**DRB Comments Response Letter:**

November 17, 2022  
City of Albuquerque  
Development Review Board

Re: **DRB Comments for PR-2022-007664**  
**Luxelocker, Luxury Boat & R.V. Storage**  
**San Diego Avenue NE, Albuquerque, NM 87113**

SHEET NUMBER
FA-1.0

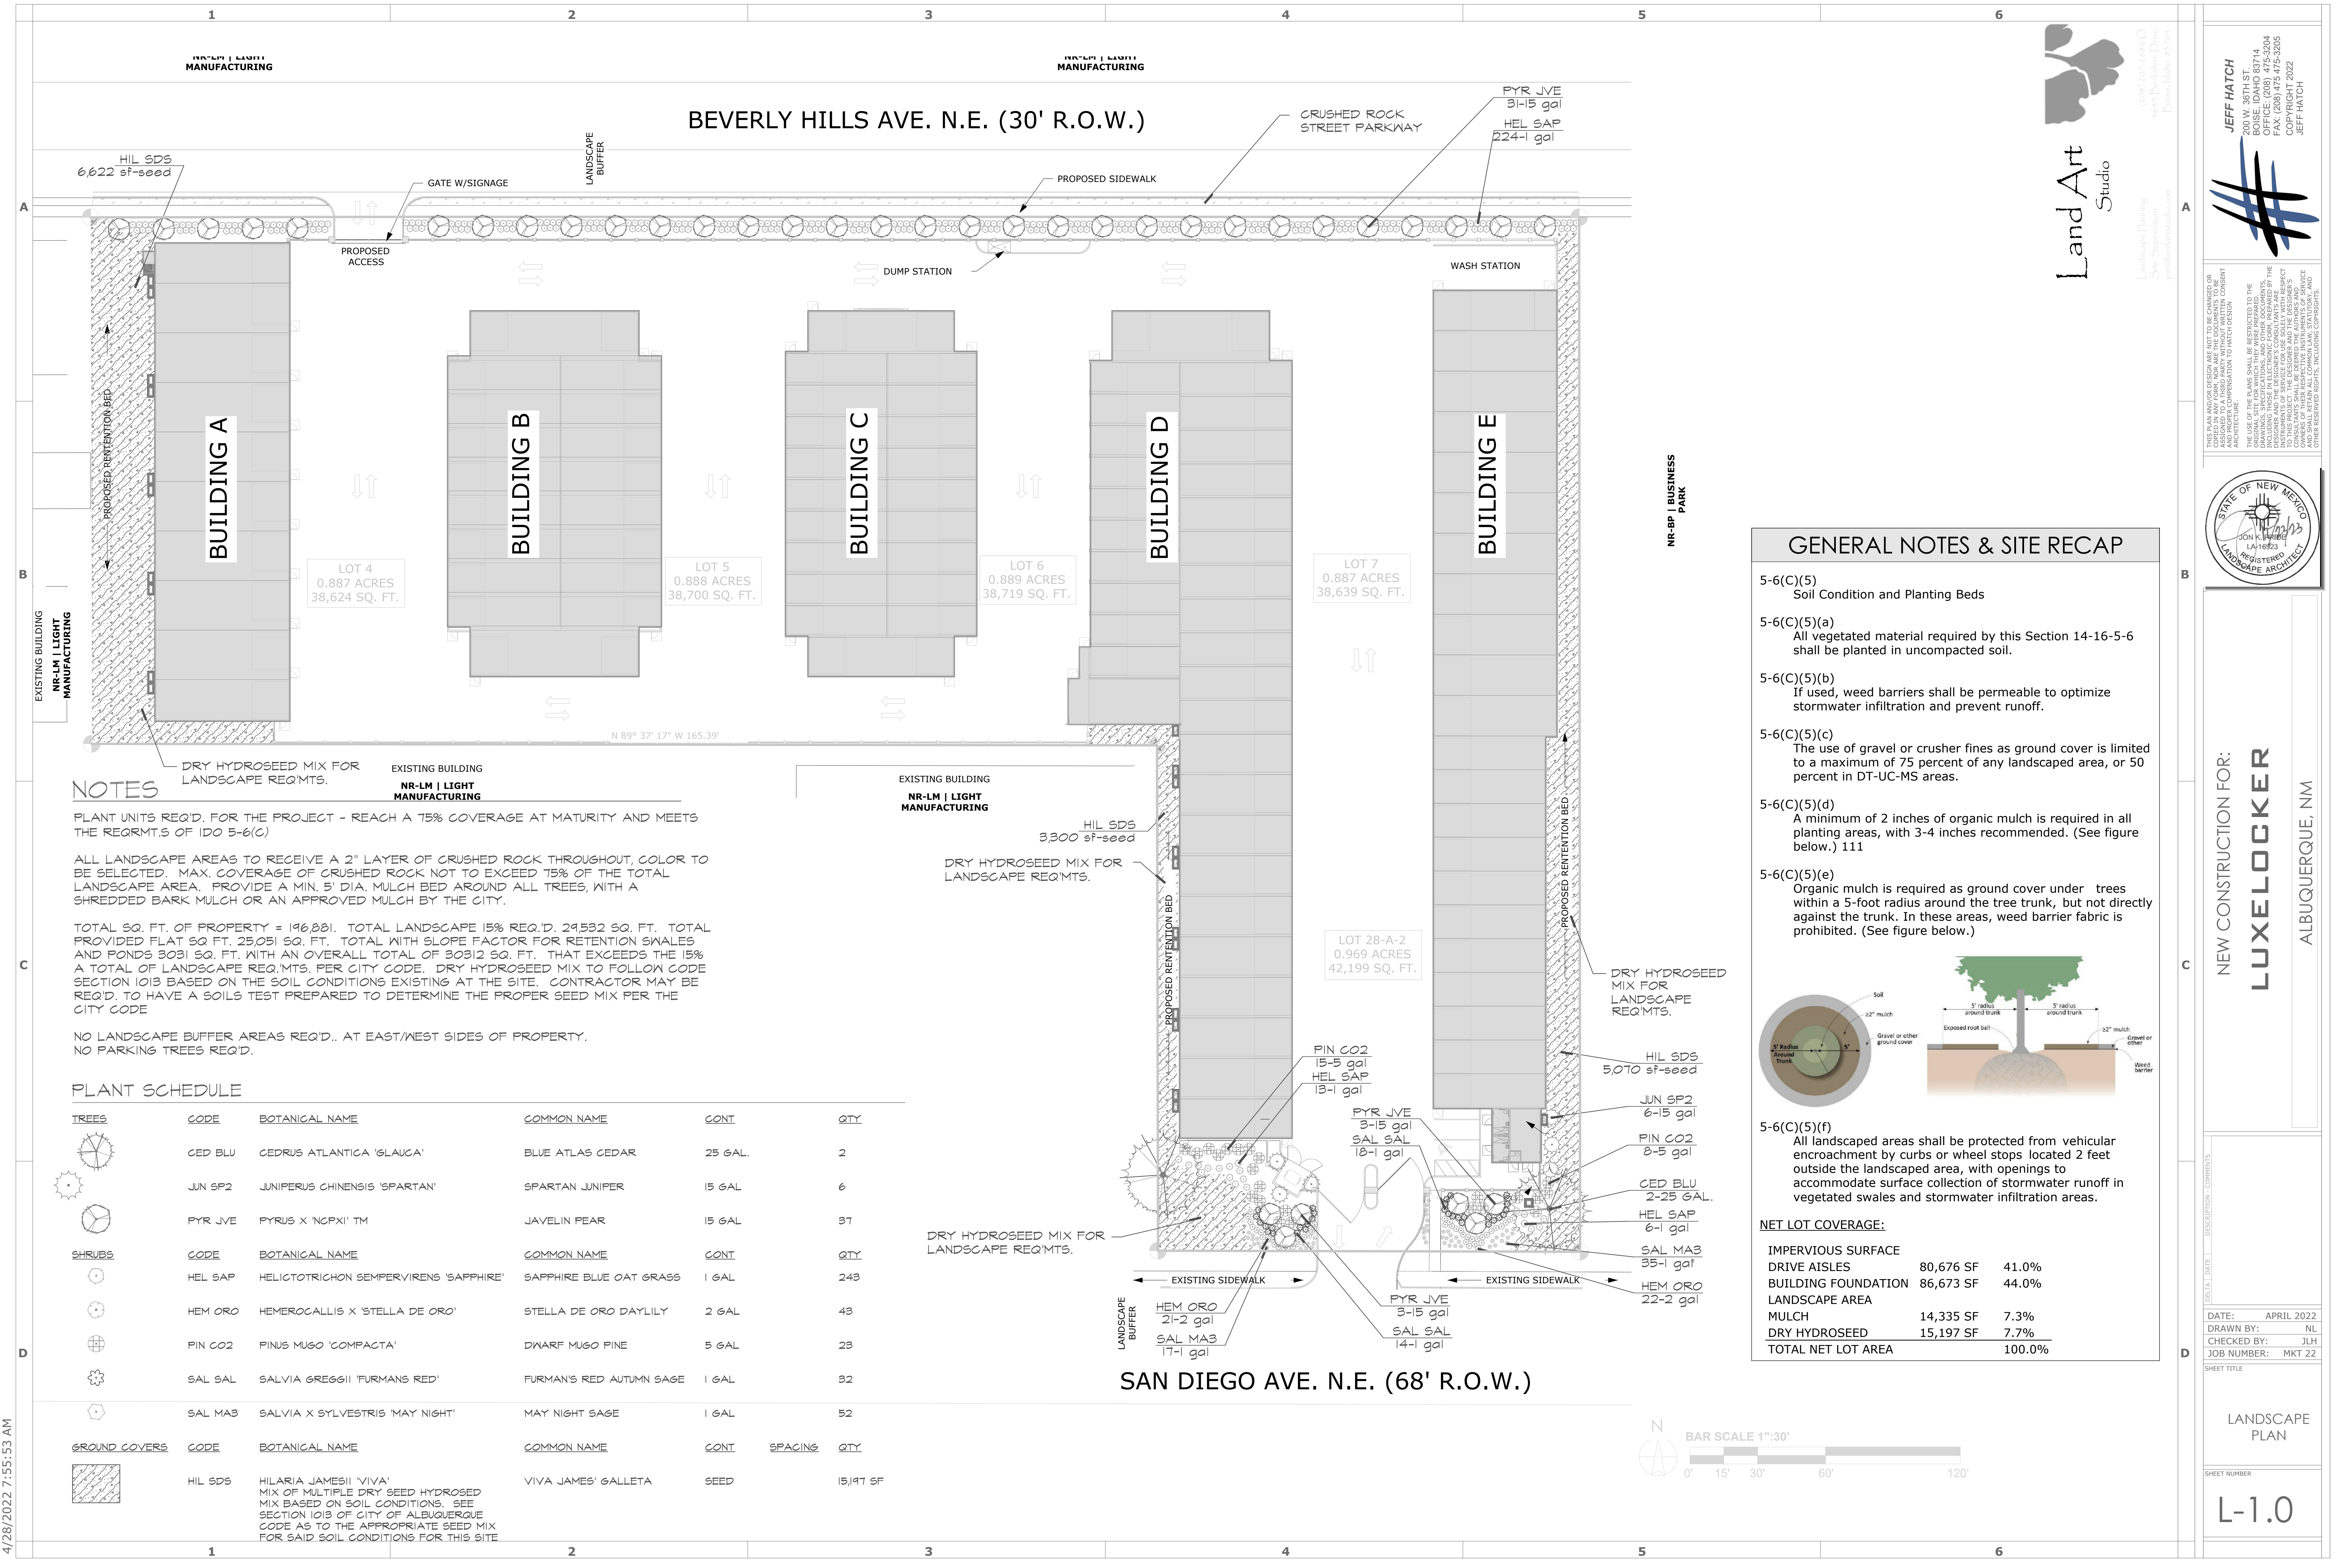
- c. ~~3-4(K)(4)(b) Confirm that these Building Design requirements have been met.~~
  - d. **Updated 11.1.22:** The applicant has met one façade requirement by adding a 1-foot in depth awnings on three buildings facing Beverly Hills Avenue (for 126 ft which is greater than 30% of the façade length) and one building facing San Diego Ave. The second façade requirement is met by providing a primary pedestrian entrance at the office facing San Diego Ave.

**R6d. Please see updated FA-1.0 Façade Design and Details indicating façade requirements that are met and calculations for both Beverly Hills Ave. N.E. and San Diego Ave. N.E.**

Plan View
Scale - 1" = 20'

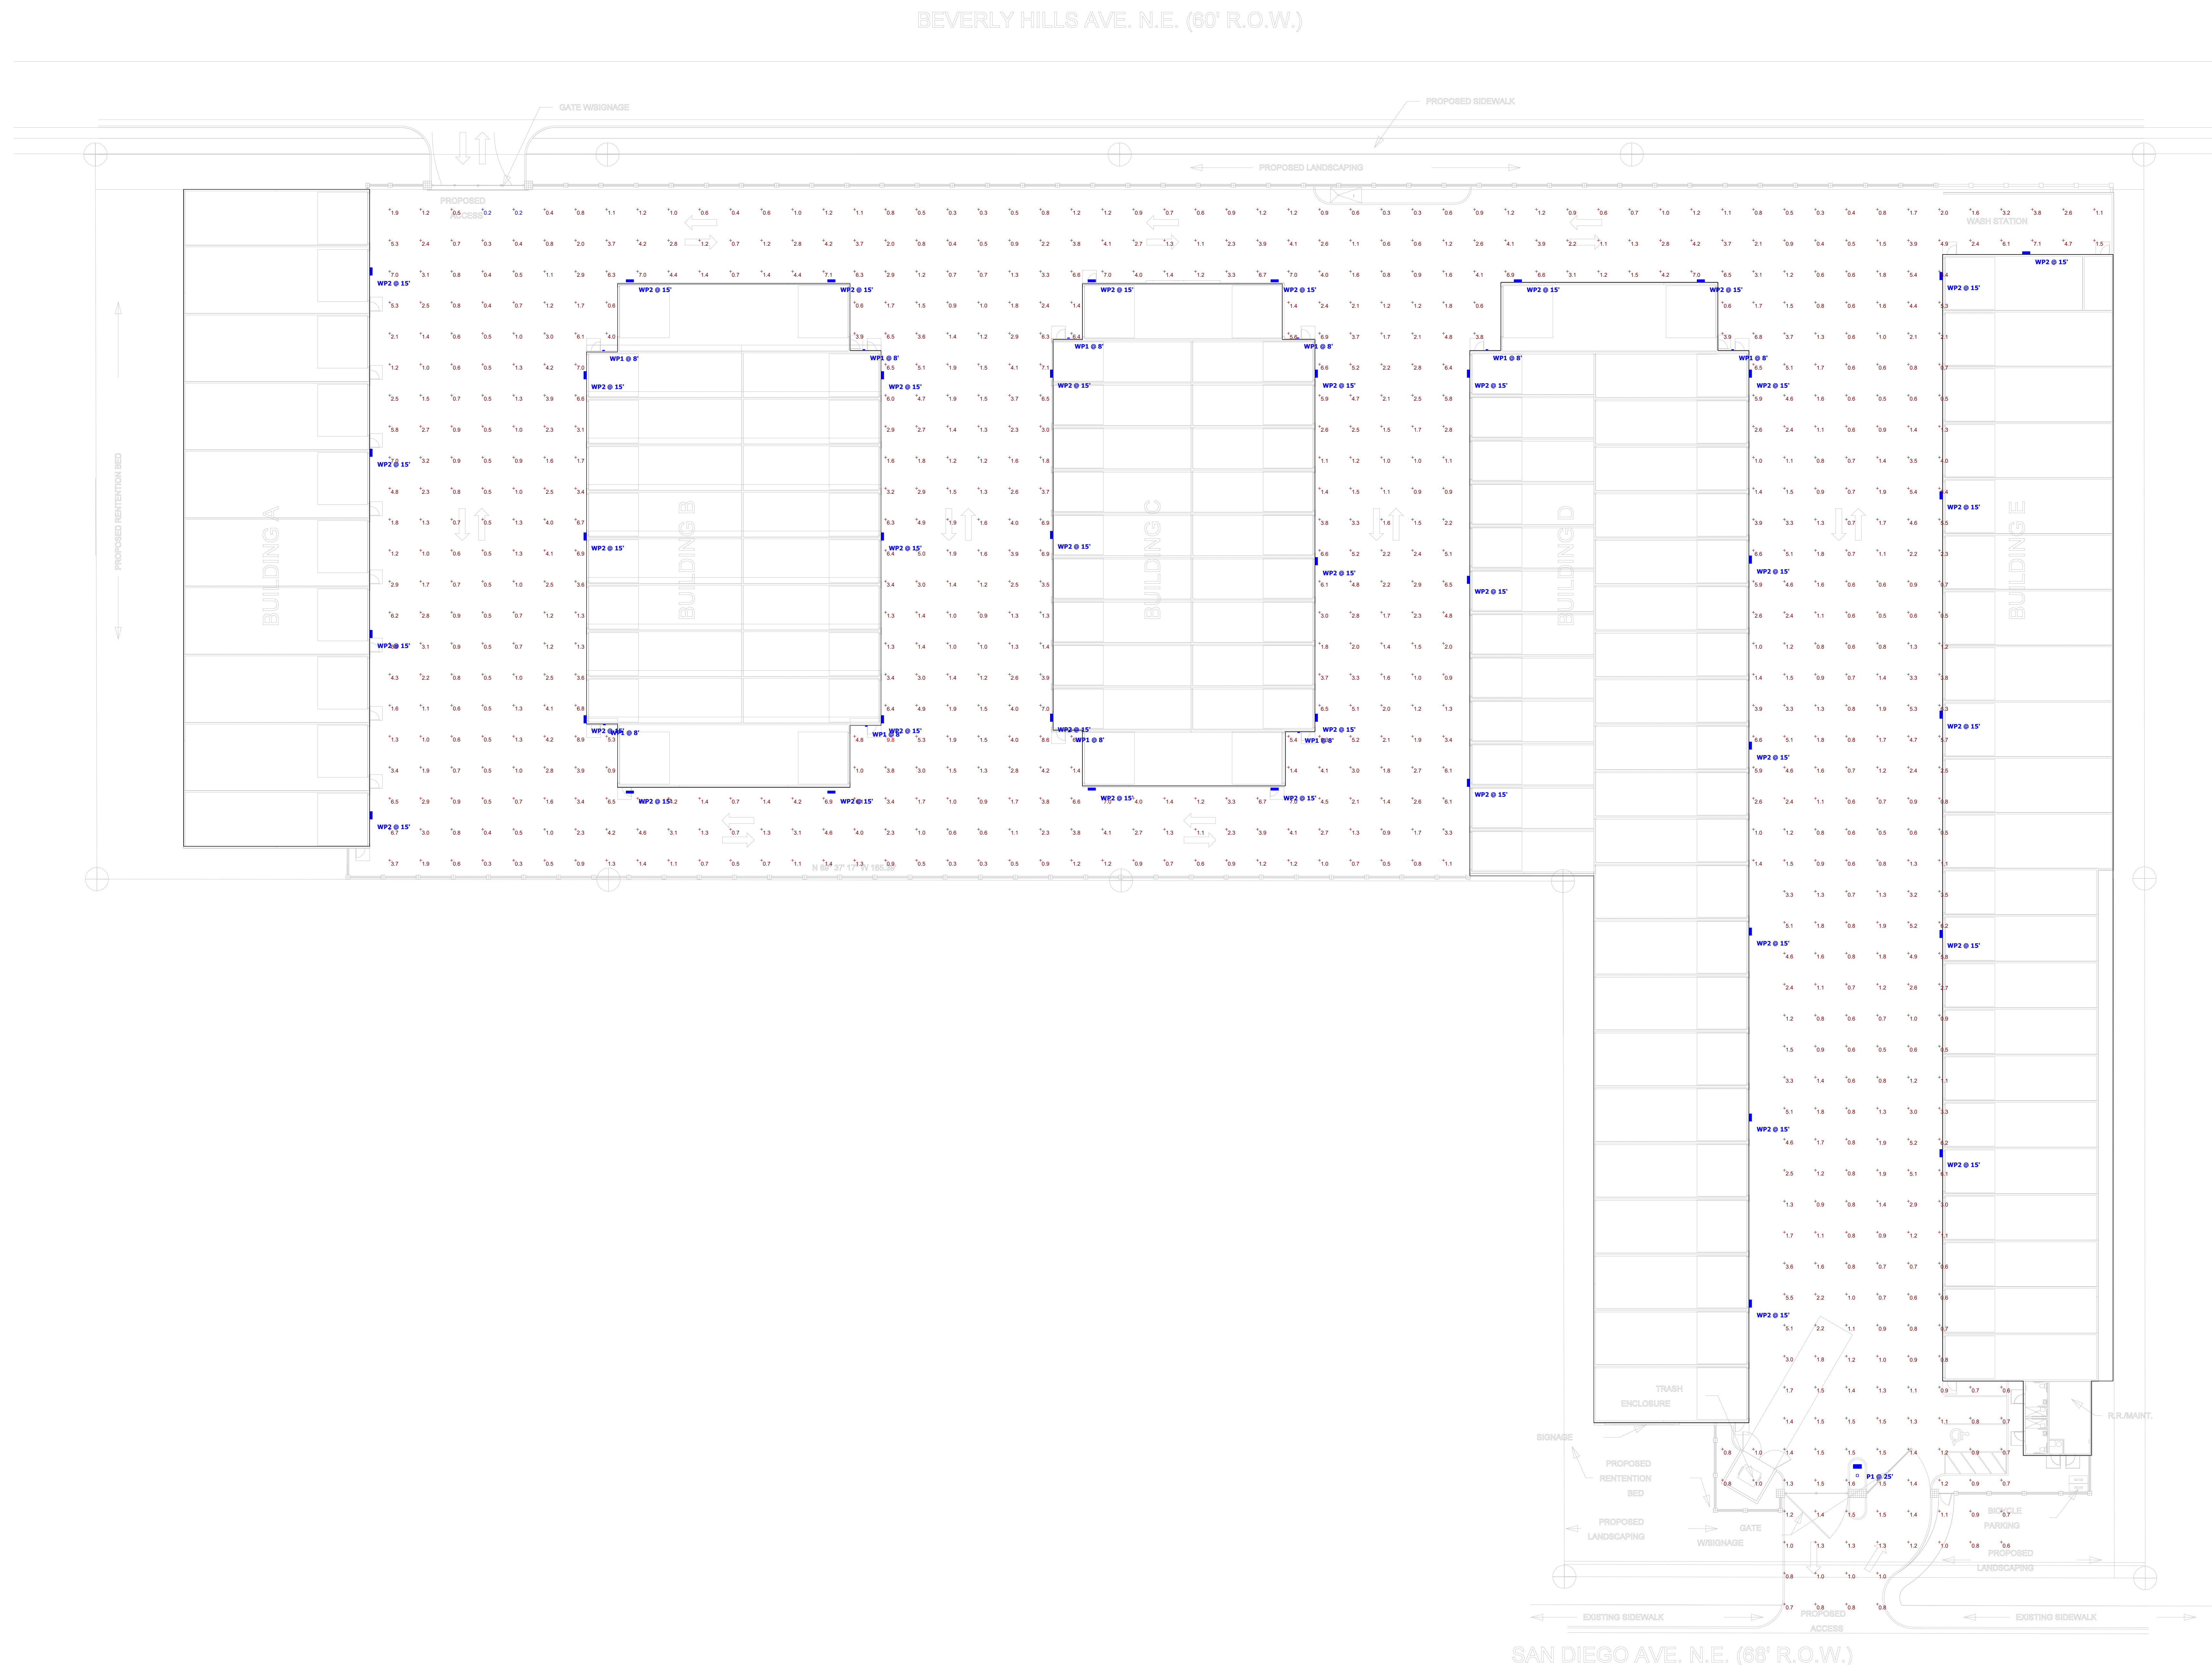
- b. 3-4(K)(4) 1. The height of light poles within 330 feet in any direction of Balloon Fiesta Park as delineated on its approved Master Plan shall not exceed 20 feet.

**R6b. The photometric plan shows our single light pole that is at 25'. No part of our property is within 330 feet in any direction of Balloon Fiesta Park as delineated on it's approved Master Plan.**

TWO REQUIRED SINGLE FACE NON-ILLUMINATED GATE DISPLAYS
15 SQUARE FEET EACH SCALE 3/4" = 1'-0"

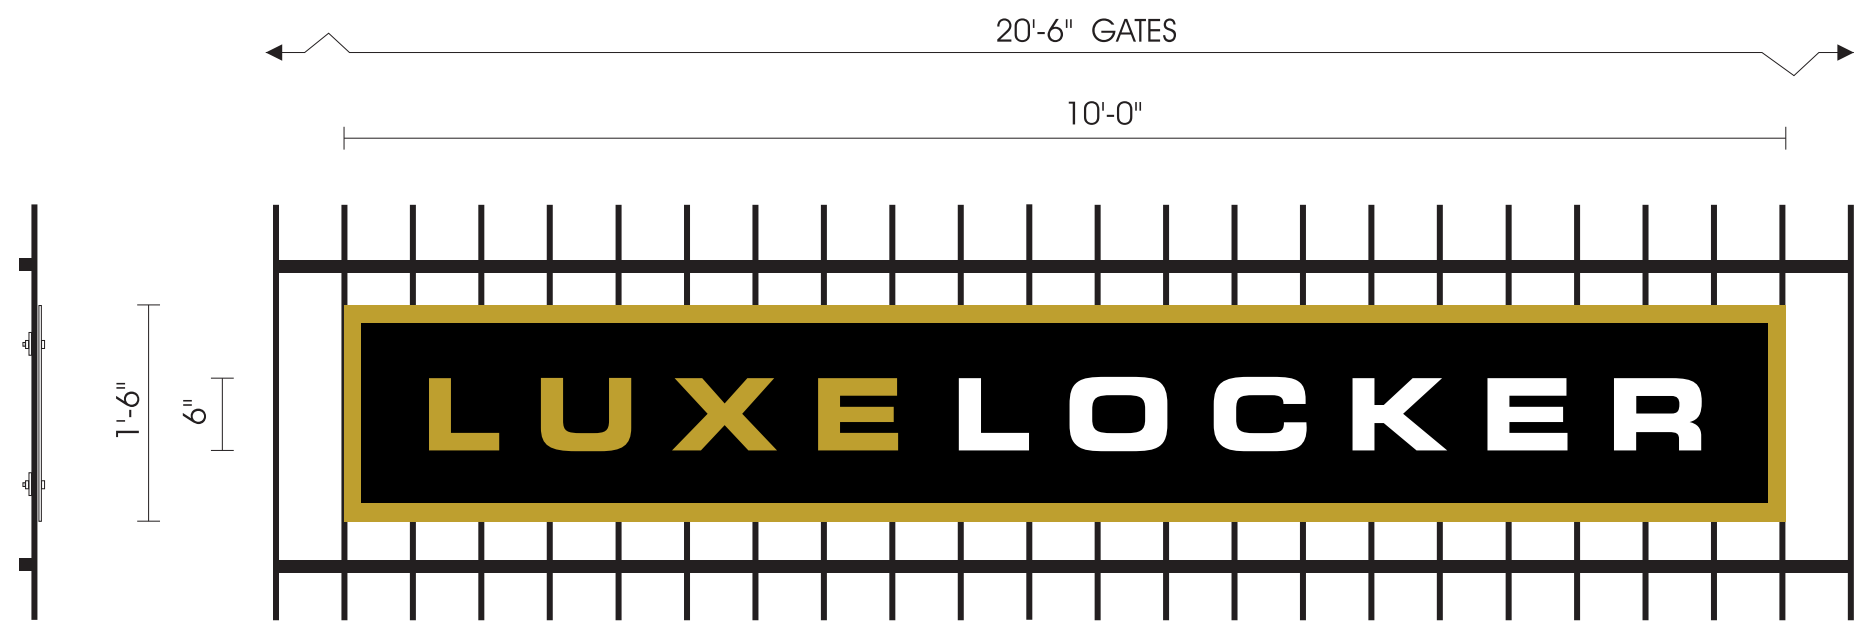
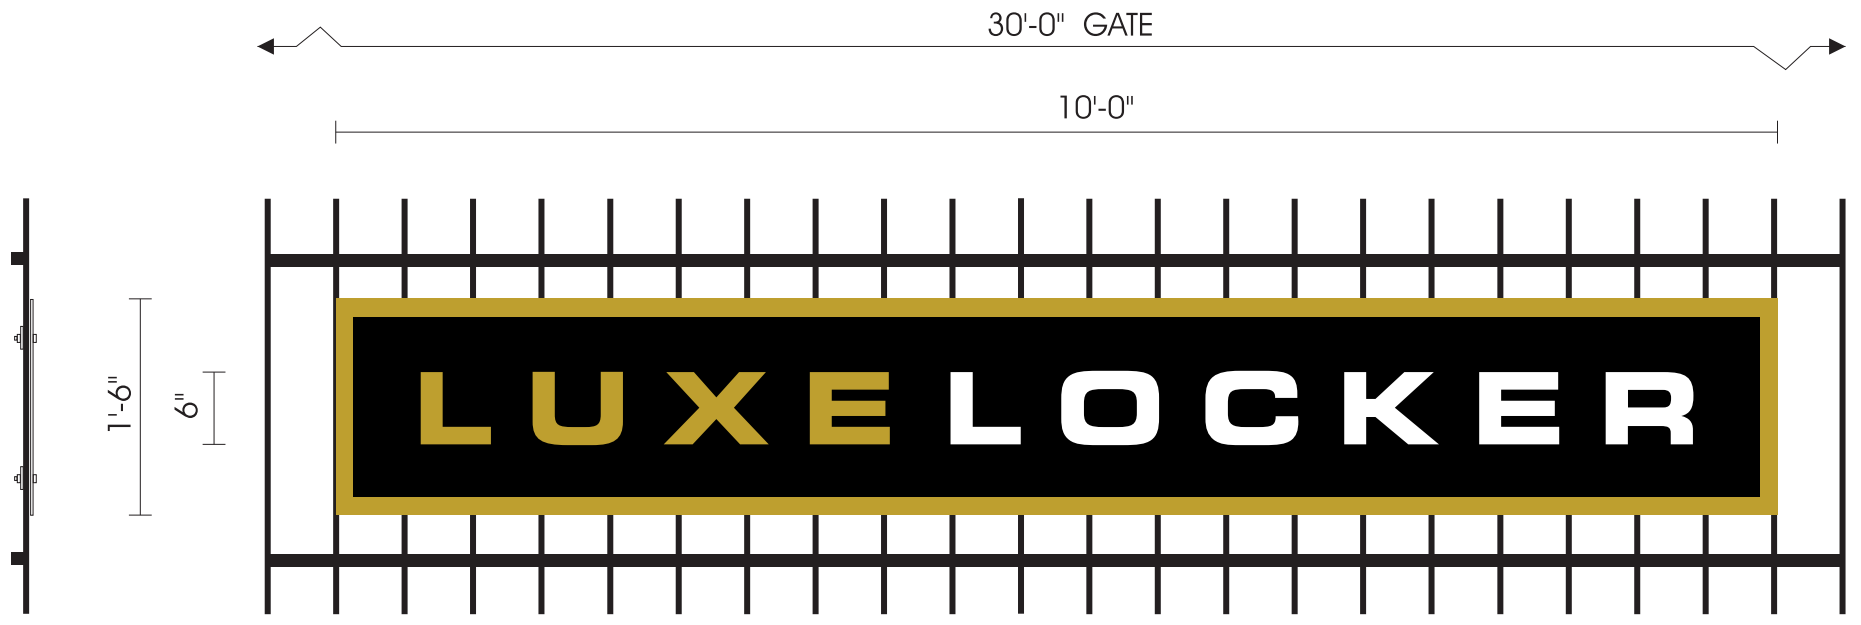
- e. 3-4(K)(4)(c) Confirm that the On-Premise Sign requirements have been met.
- R6e. We are currently calling out (3) 4'-0" x 24'-0" backlit, illuminated signs on the property. The standards that apply to backlit, illuminated signs are as follows:**

**3-4(K)(4)(c) "Sign standards for the MX-M zone district in Subsection 14-16-5-12(F) (On-premises Signs) apply in the Mixed-use and Nonresidential zone districts of CPO-10 unless specified otherwise in this Subsection 14-16-3-4(K)(4)(c)."**

**5-12(E)(5) Illumination and Motion - Table 5-12-2: On Premises Signs in Mixed use and Non-residential Zone Districts**  
**3-4(K)(4)(c) Indicates we must use MX-M zoning regardless of the properties zone to determine on-premises sign requirements. Table 5-12-2 further states (under zone MX-M) wall signs shall not exceed 15% of façade area, inclusive of door and window openings. All current proposed signs are well under 15% of the façade area.**
